# ADDITIONAL INFORMATION REPORT

MP 11\_0048

61 MOBBS LANE, EPPING – STAGE 2

MARCH 2012

1 CV - GROUND FLOOR PLAN  
1 : 200

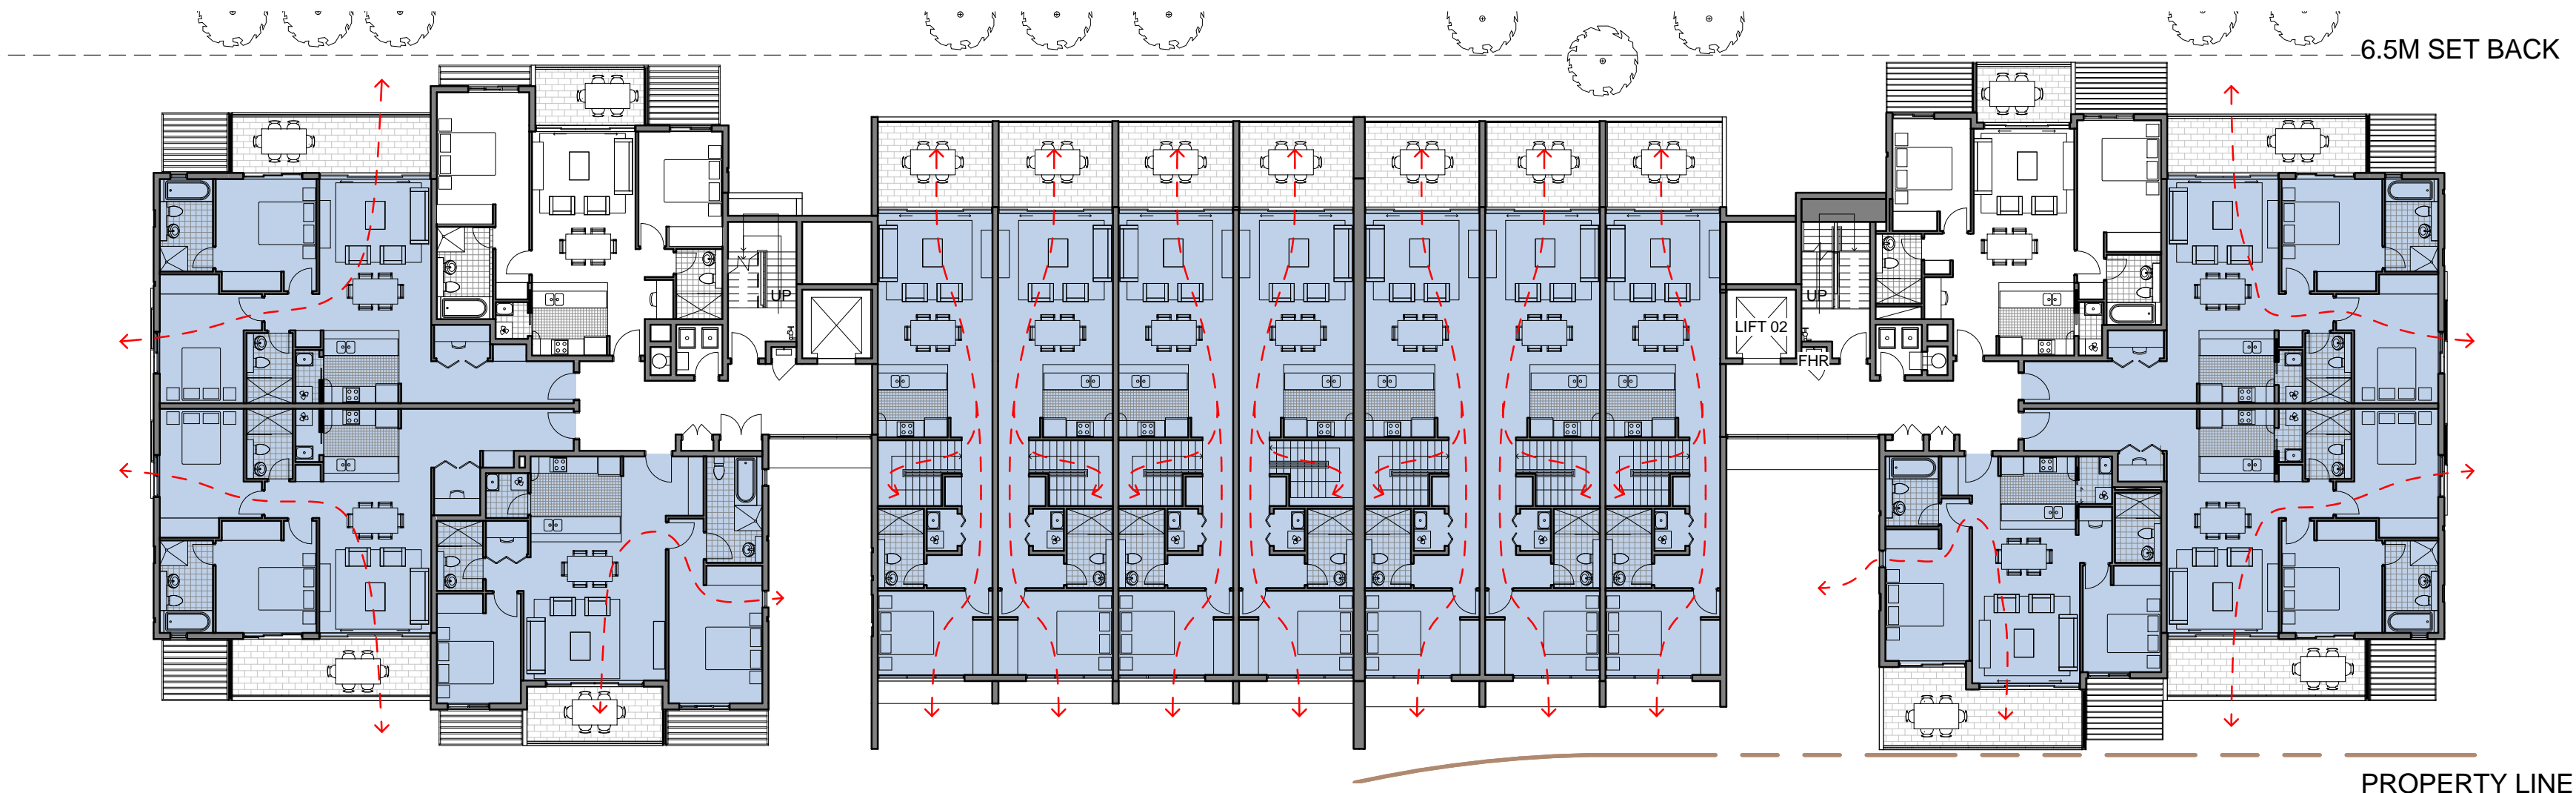
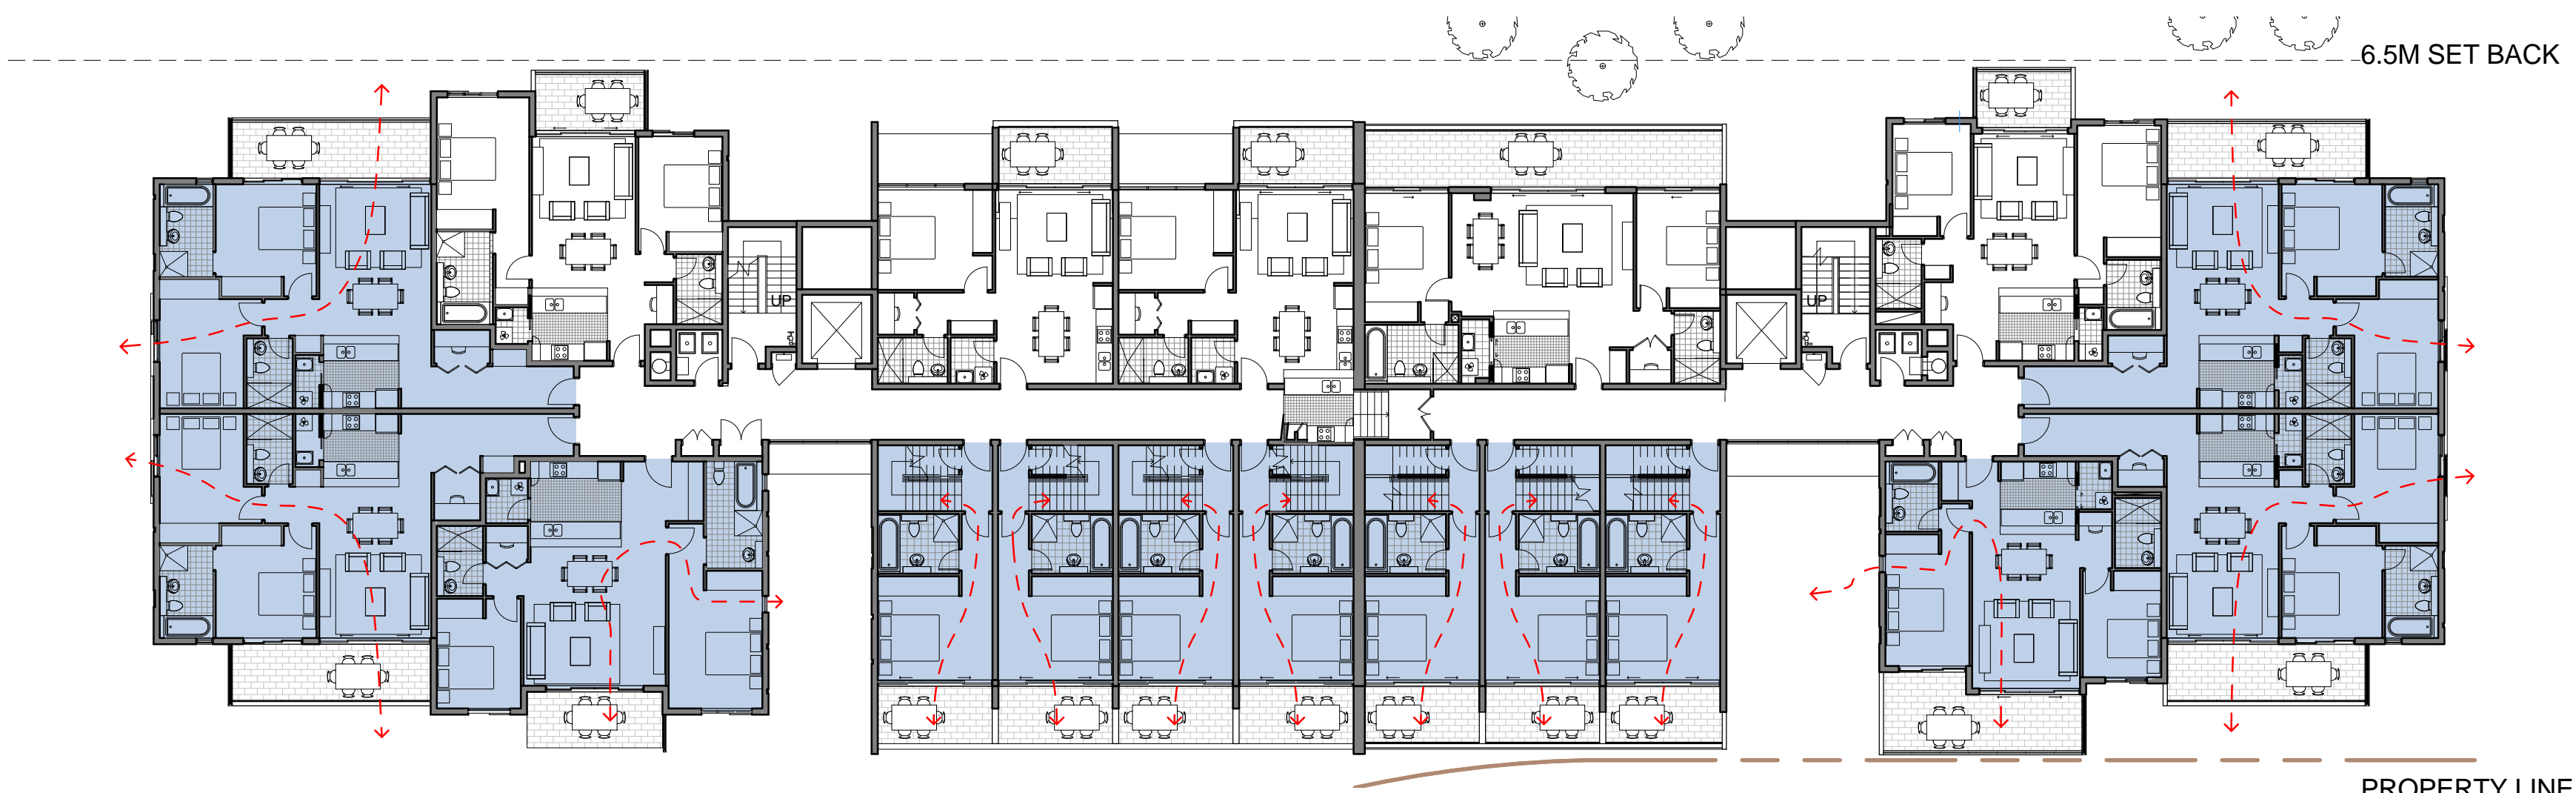
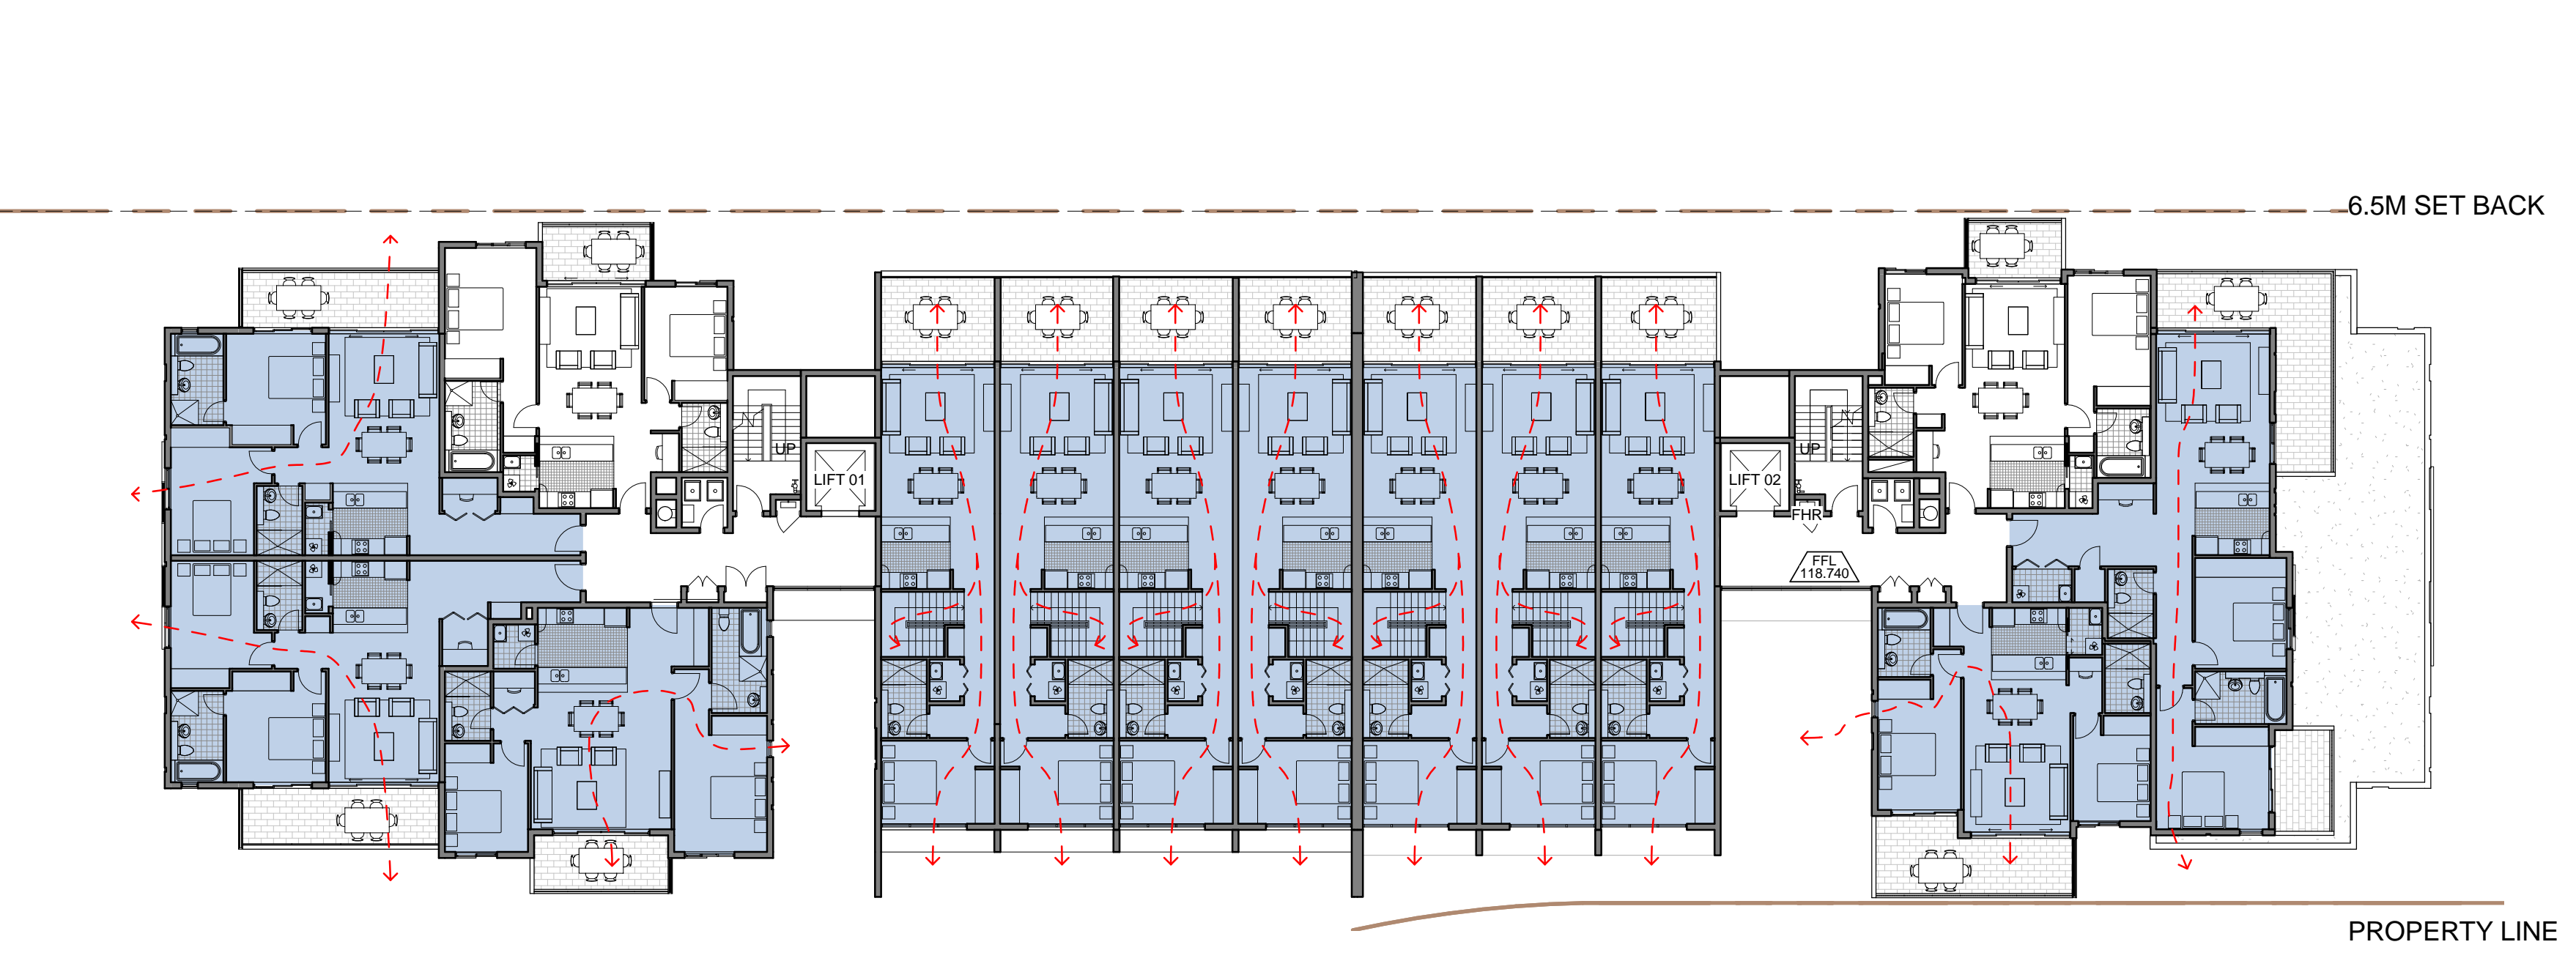
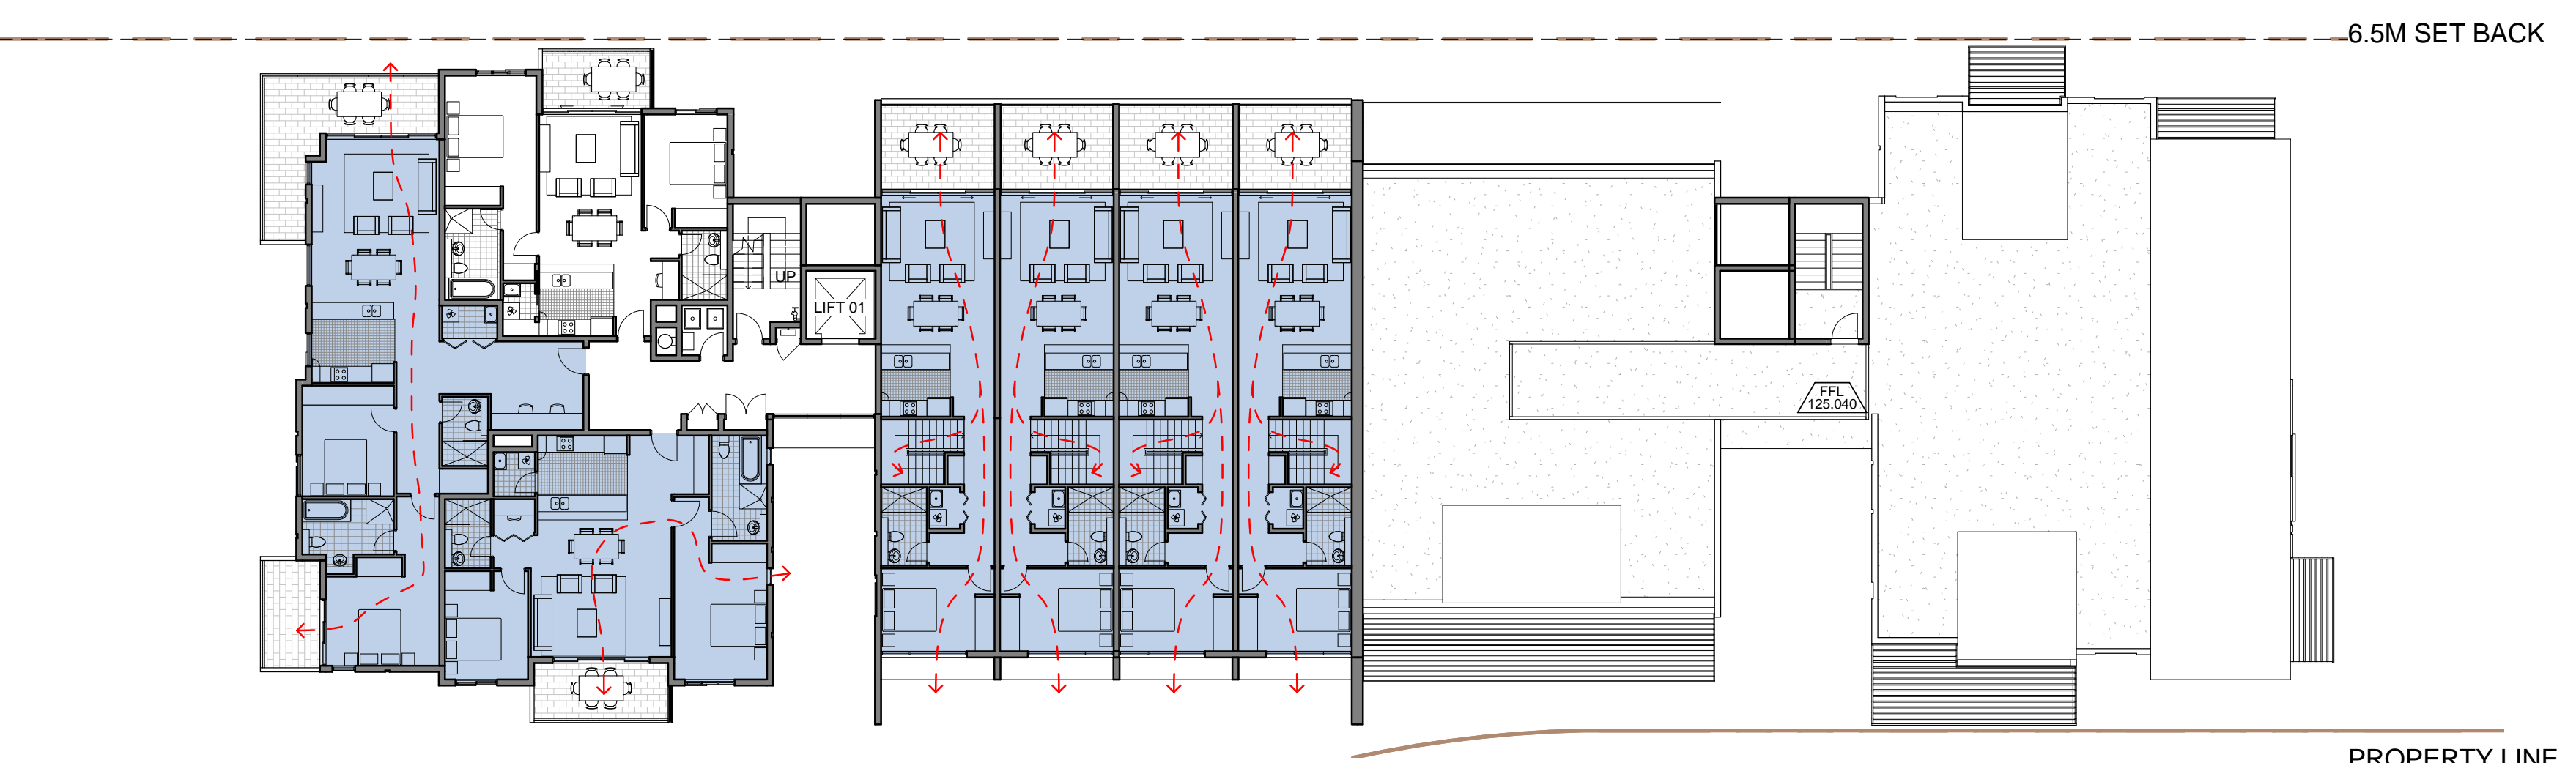
**Issue:** Natural ventilation: DoP considers that only 50% of apartments are cross ventilated.

**Response:** Buildings have been purposefully modulated and windows carefully located to ensure that buildings have more than 60% of units with cross ventilation as outlined below:

- Building 6 – 68%;
- Building 9 – 66%;
- Building 10 – 83%.

Refer to ***Annexure 7***.
